TOWN AND COUNTRY PLANNING ACT 1990 FULL

Reference: H23-1062-24 **Date of Decision:** 13th March 2025
Applicant: Mr D Dlugosz
Valencia
Cranesgate North
Whaplode St Catherine's
Spalding
PE12 6SR
Location: Valencia Cranesgate North Whaplode St Catherine Spalding
Description: Use of site for storage of campers and caravan trailers

SITE PLAN - EXISTING
LOCATION PLAN

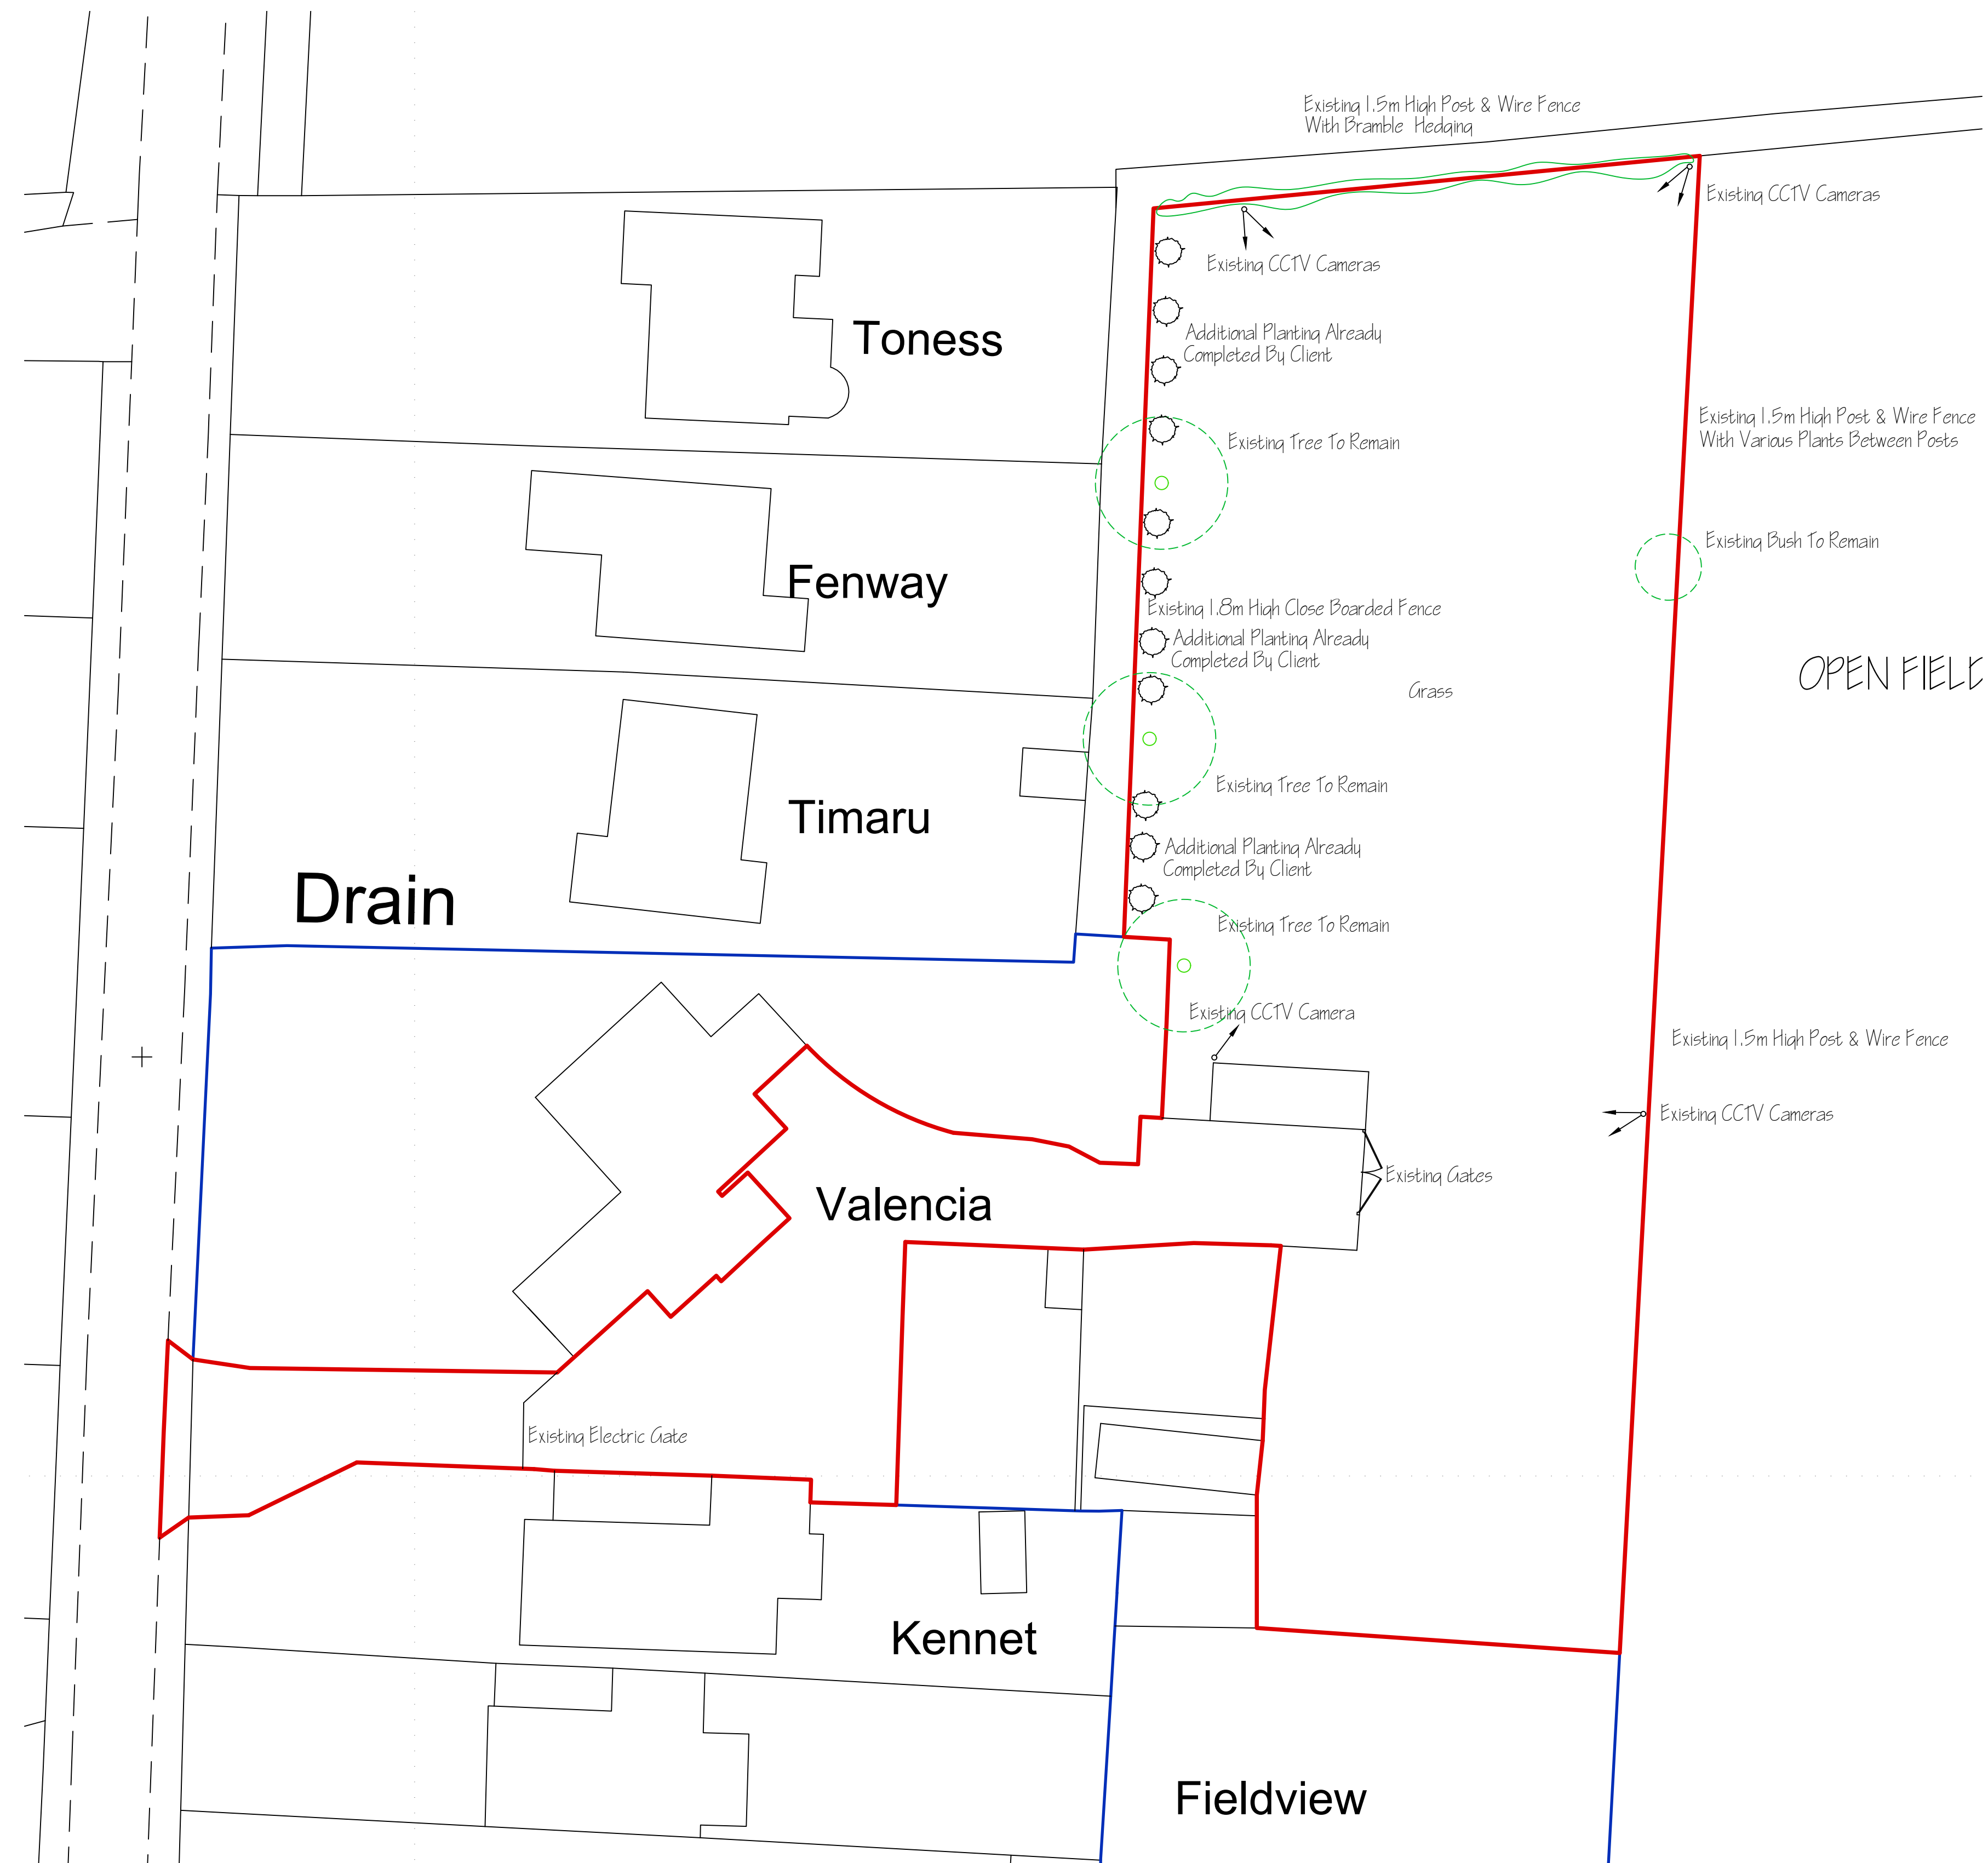
- 2 It is considered that insufficient information has been provided to demonstrate that a safe access/egress to the development can be achieved. The proposal is therefore contrary to Policies 2 and 3 of the South East Lincolnshire Local Plan 2019 as well as section 9 of the National Planning Policy Framework (December 2024).

- 3 The proposal fails to recognise the intrinsic character and beauty of this part of the open countryside as well as having an unacceptable impact upon the visual amenity of neighbouring residents. The proposal is therefore considered to be contrary to Policies 2 and 3 of the South East Lincolnshire Local Plan 2019.
